LANDSCAPE PLAN

CBP 9-2
CLAREMONT BUSINESS PARK
 1405 SELIX GROVE
 COLORADO SPRINGS, CO
 PREPARED FOR:
 Hammers Construction, Inc.

JOB NUMBER	740-18
REVISIONS	
ORIGINAL DATE	1-25-18
DRAWN BY	JM
DESCRIPTION	LANDSCAPE PLAN
SHEET NO.	6 OF 9

**LANDSCAPE PLAN**

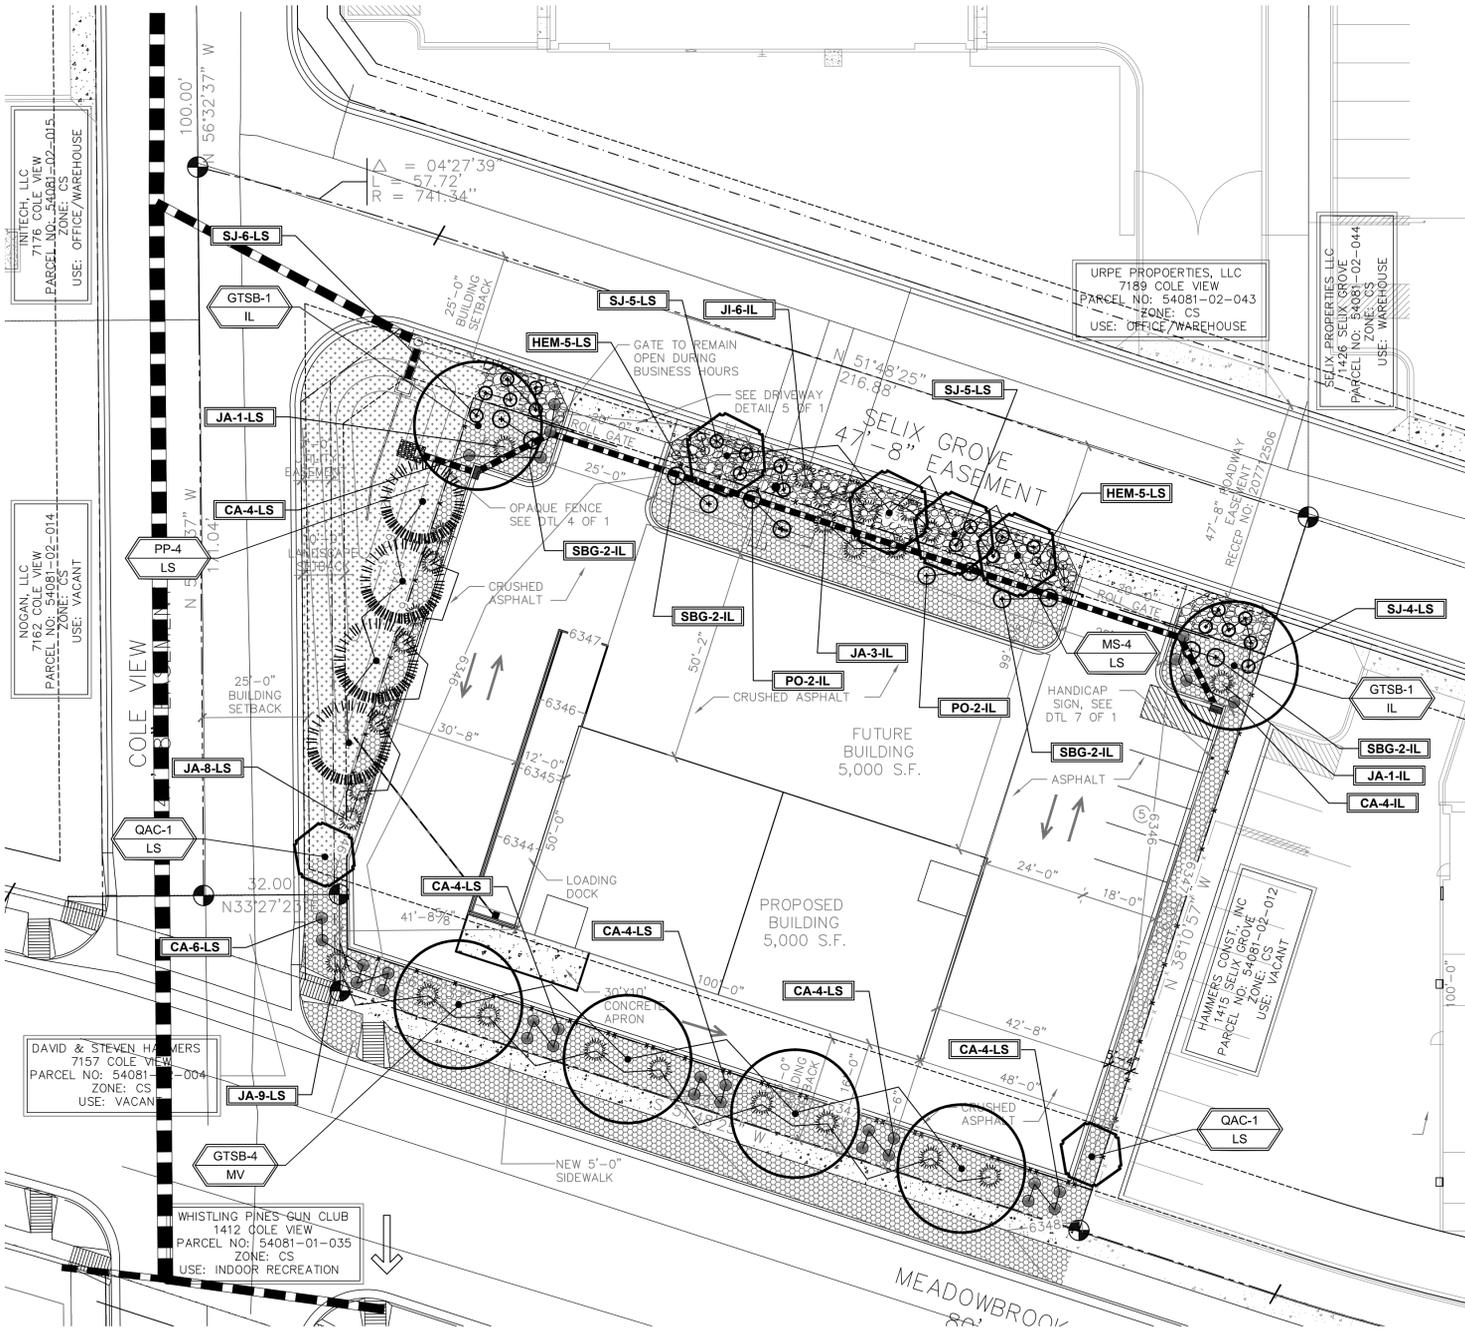
This should be completed

How much is provided?

The loading dock needs to be screened. LDC 6.2.G.1.c.
